Winchester City Council statement on Biodiversity.

21 December 2020

WCC has noted the information submitted to date by the applicant relating to its questions on biodiversity impacts at Lovedean and at Denmead Meadows. The Council has also noted the information contained within the Statements of Common Ground between Aquind and relevant parties. The Council is aware of the impending submission of a further biodiversity paper at D6. However, the responses below are confined to the detail already within the public arena. The Council continues to have outstanding questions relating to the impacts/proposals at Lovedean and Denmead Meadows.

Figure 15.49: Indicative Landscape Mitigation Plan Option B(1) (south)

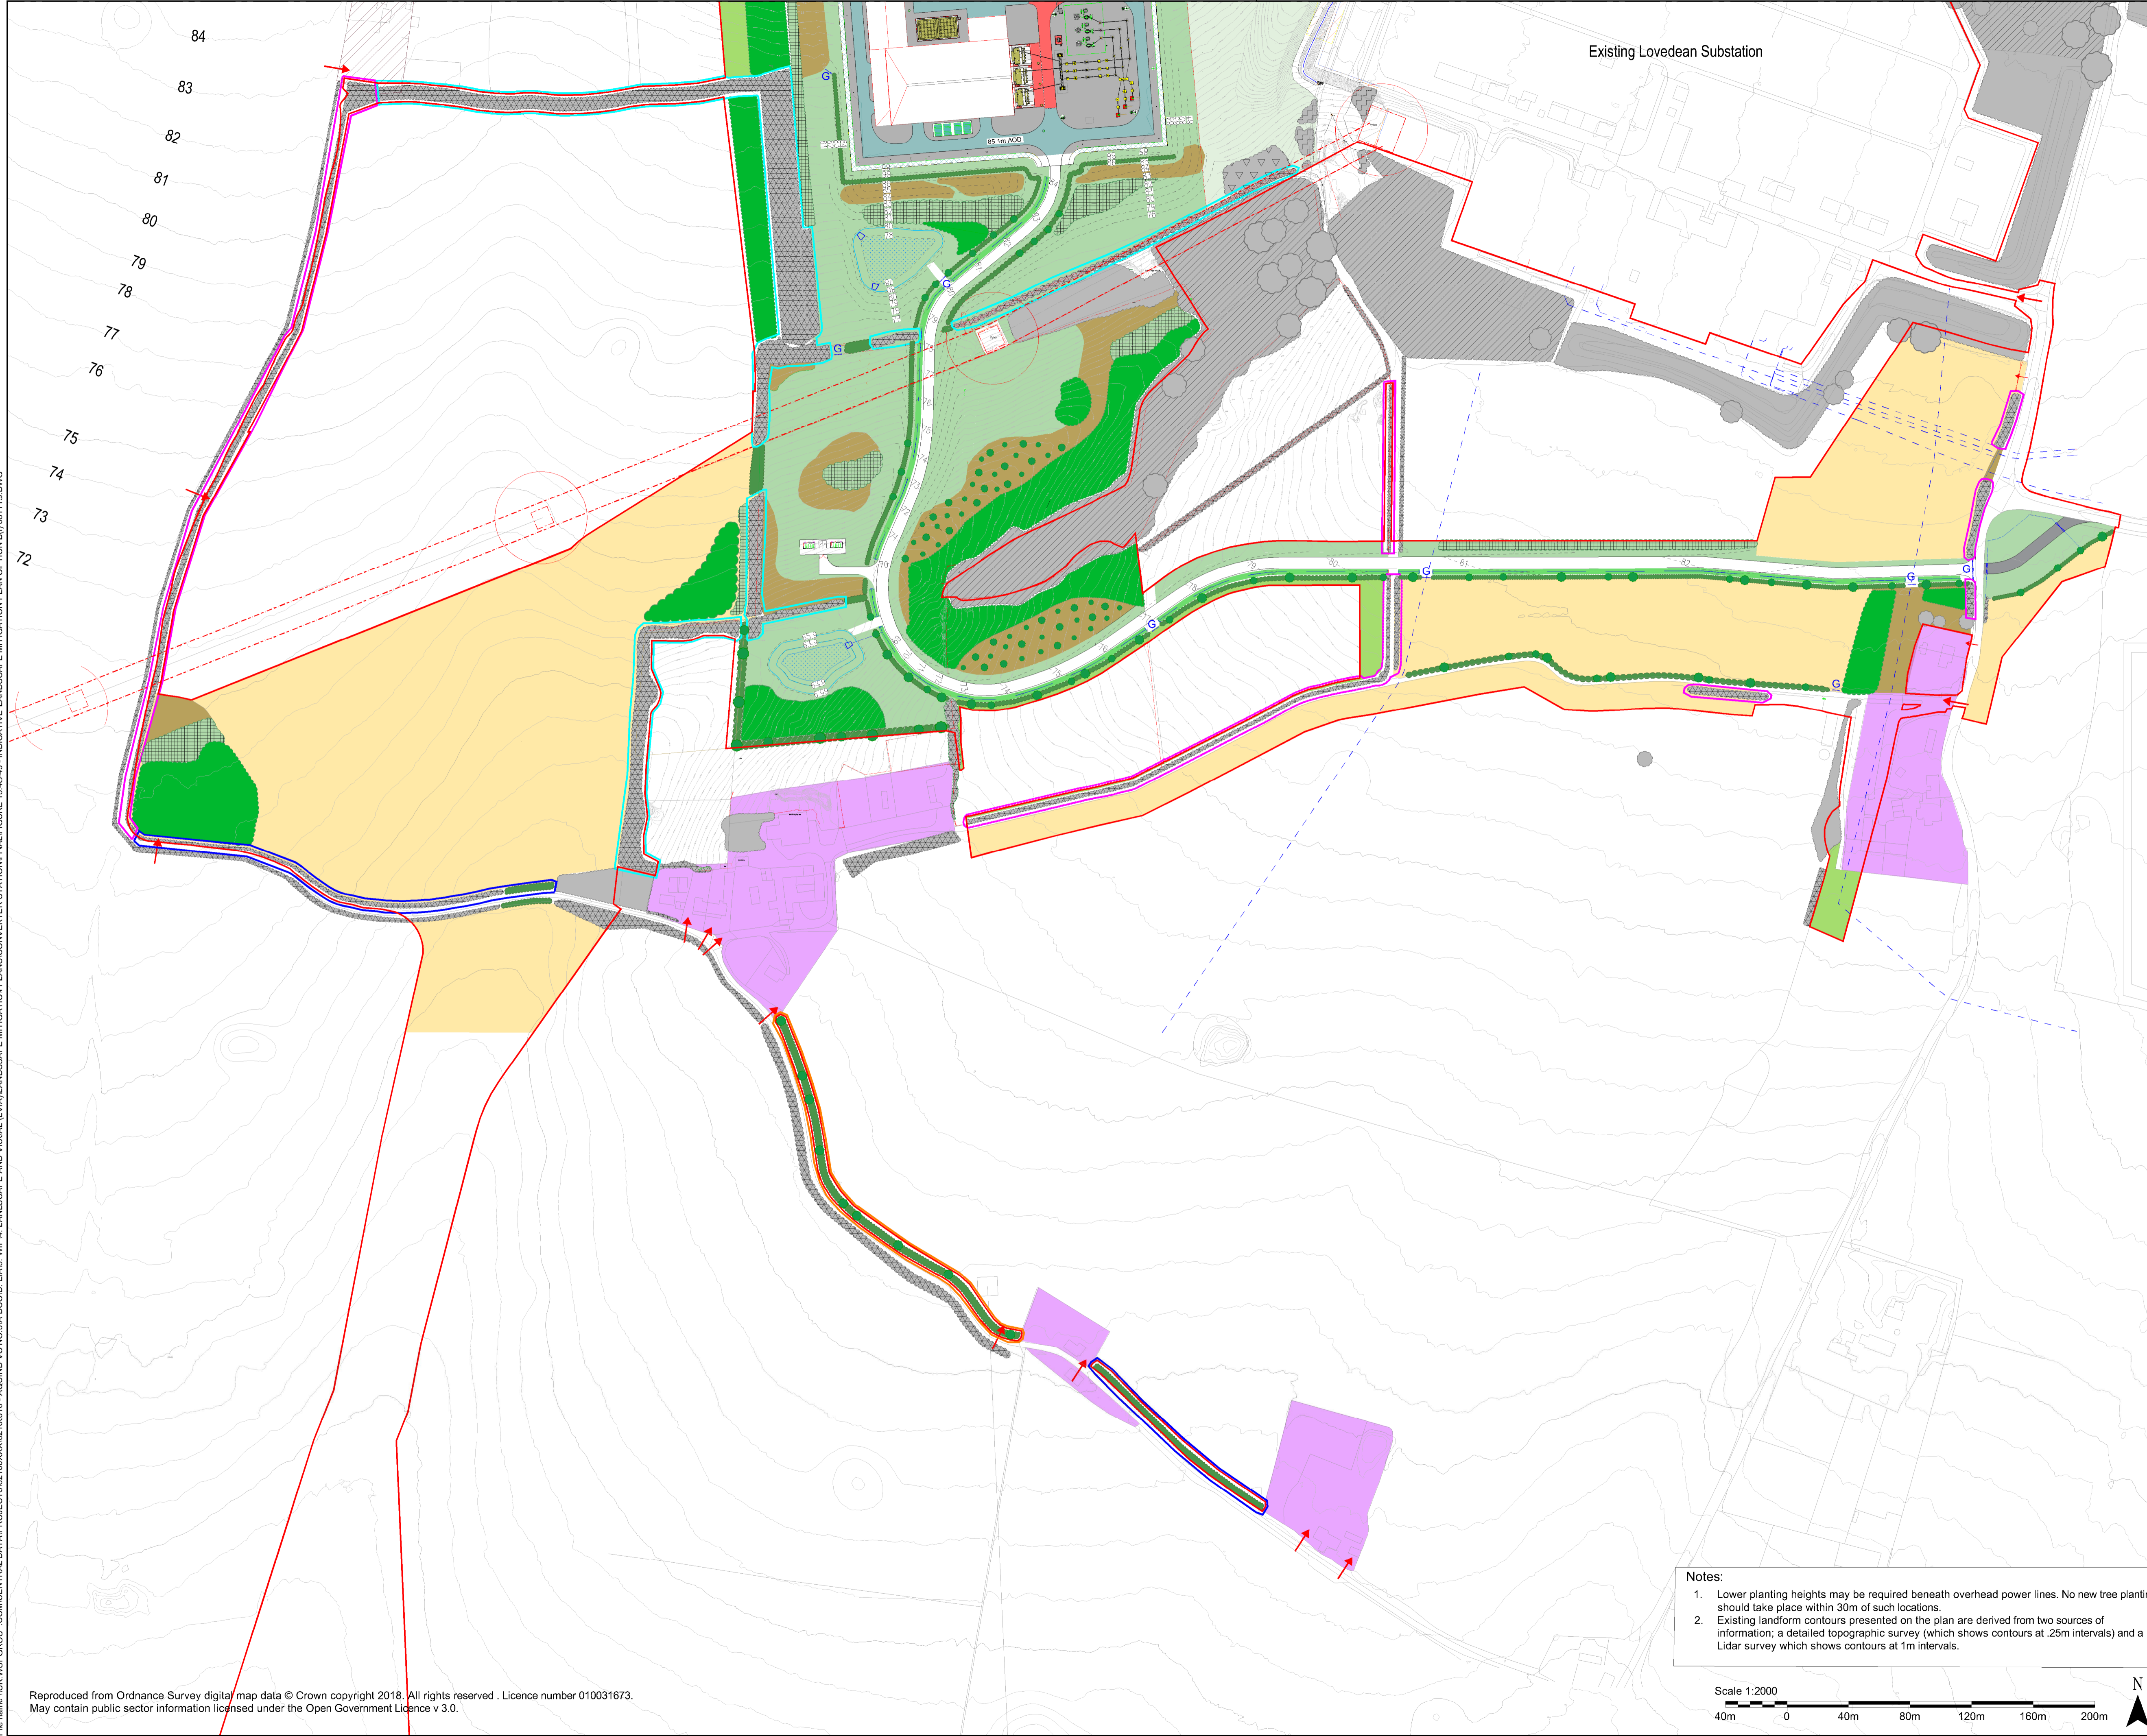
1. Final responses to the actions proposed by WCC to enhance the new planting as outlined previously.
 - In the draft SoCG with the Council it seems that some of the issues have been adopted but possibly not all. It is understood that a new landscaping plan will be submitted at D6 and the Council will review and comment on this at D7.

- **Question:** How will the calcareous grassland be established on what is a clay/loam soil and sub soil base with a combined average depth of 1m?.
 - The latest response to this question has generated two options. Either, the removal of the top soil and sub soil down to the chalk bed, or the inversion of the soil/clay and chalk. Both actions would seem to place a heavy use on construction plant and equipment.

- **Question:** Considering that other priority habitats such as deciduous woodland could be formed on the site, why expend all the resources establishing a calcareous grassland?

- **Question:** Some of the parcels of land that are shown as grassland are small odd sizes; might these not be given over to other habitats?
 - **Question:** If the top soil and sub soil is removed, how would the spoil be disposed of?

- **Question:** With the first option, how would the differences in ground levels be accommodated on site where existing features such as hedges or trees and solid structures such as the base for pylons exist? Will landscape features not end up on top of banks with all the stress that can create to their survival or establishment in the case of new planting?

- **Question:** Following on from the above will the resultant topography not appear erratic ?

- **Question:** Regarding both options, have the implications on surface water drainage been taken into consideration?

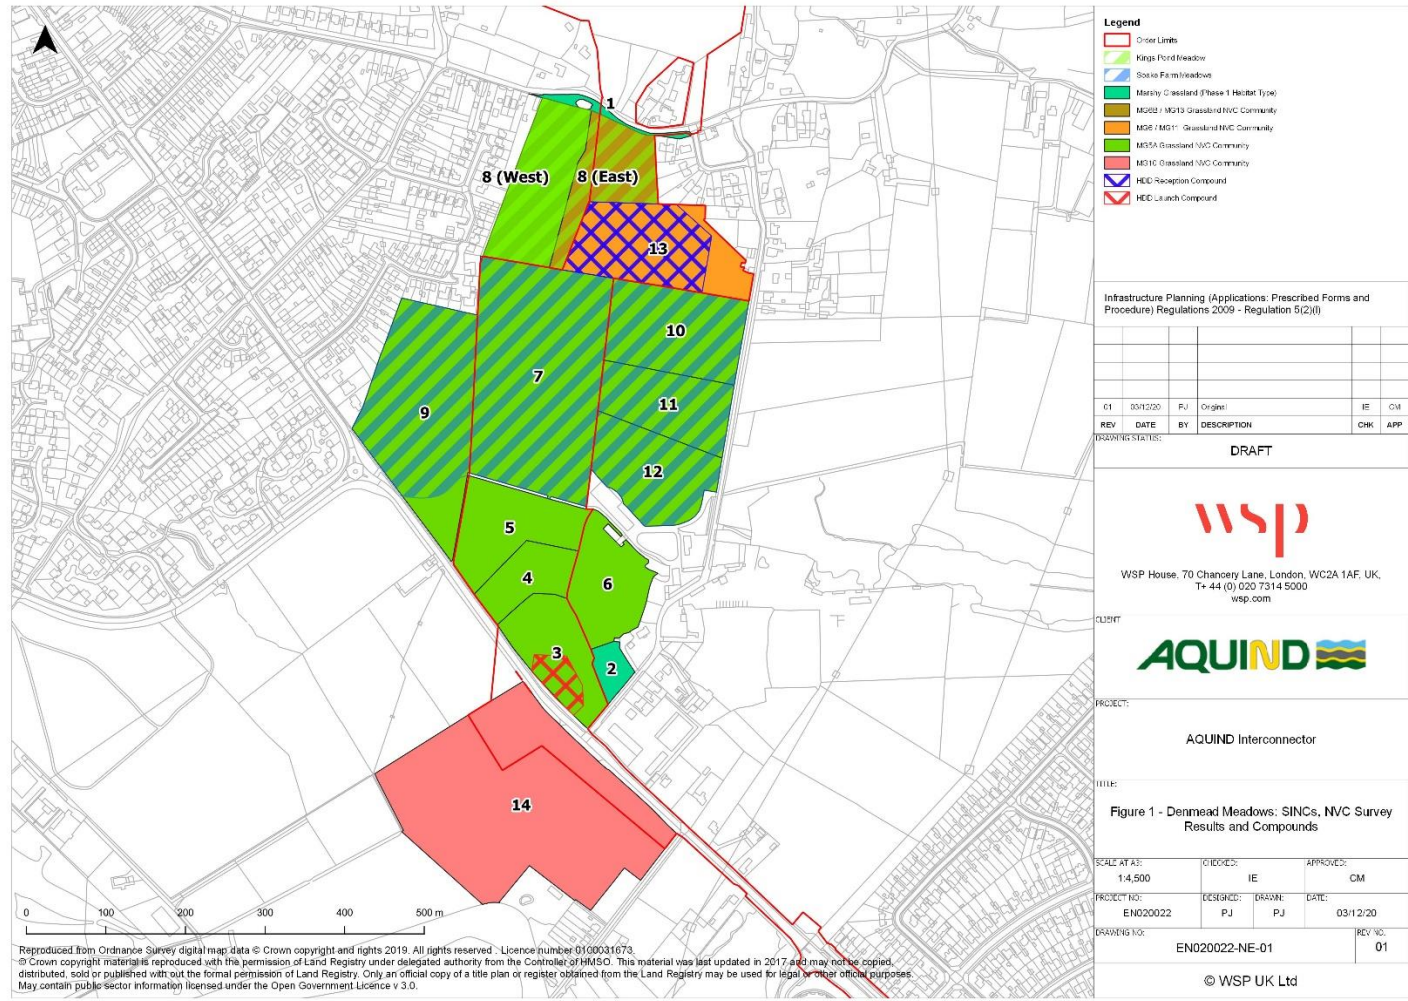
1. WCC understands that there are two options under consideration for the location of the HDD launch compound. The first site is located on the south side of the Hambledon Road and the second on the north side of the road.

2. As a principle, WCC supports the southern location, which would avoid any need to disturb to Field 3 at Denmead Meadows.
3. WCC notes the reference to technical issues with the use of the southern compound, which it is understood, relates to the cable achieving a bend to enter the underground drill section to then be pulled through. If a jointing bay were located at this point, would that not allow the cables to make a more acute change in direction? Whilst this may result in more connections between lengths of the cable than desired, it has to be considered against the acknowledged harm that will result to the biodiversity value of the land on the north side of the road if the compound is located there.

4. The cable exit from the Hambledon Road into a compound on the south side of the road may impact a longer section of hedge. However, on balance this is preferable if it retains the full integrity of the land on the north side of the road.

Question: When does the applicant anticipate making the decision on the choice of the location of the launch compound?

7. On the north side of the road, the Council would like the applicant to affirm that no trees on the Hambledon Road frontage will be lost when the cable or vehicle access enters Field 3. This should be accomplished by the identification and further analysis of the proposed access points.

8. A tree preservation order has been imposed of trees on the road frontage and one tree back into Field 3. The applicant should review the access point and cable run into this land in the light of the new TPO.

9. WCC continues to express concern over the presence of the access rights strip that runs up the western side of the Order limits through Denmead Meadows parcels 3-12a & 3-13a as shown on Land Plans rev003 REP5-003.. The most recent response says that was an error and it will not be a haul route.

Question: If vehicles are not to use this strip where is this stated, given the broad nature of uses set out under the definition of “access rights” as detailed in the Book of Reference (REP5-015).

10. At the northern end, in addition to the access being cut through the roadside hedge there will also be a separate section cut out for the cable corridor. Allowing for the existing gate at Anmore Road the estimated loss is 20m + of hedge here.

Question: Is that a fair estimate? This will have a significant effect on the appearance of the boundary between Anmore Road and Denmead Meadows particularly in the short medium term whilst any new hedge establishes.

Question: It appears there is at least one tree in this vegetation. Where will the replacement be located?

Question: What is the access route on the local road network for HGVs to get to the northern compound?

11. It would appear that no special measures are proposed in Field 8 although this is part of a SINC. The Council is of the view that the poor condition of the habitat value in Field 8 is a result of its management regime and that if this changed the vegetation may well recover. The applicants approach would remove that regeneration ability forever and should be addressed. The applicant should address the impact on what is part of a designated site.

Question: As Field 8 east is part of the designated SINC the applicant needs to justify the above approach in more detail.
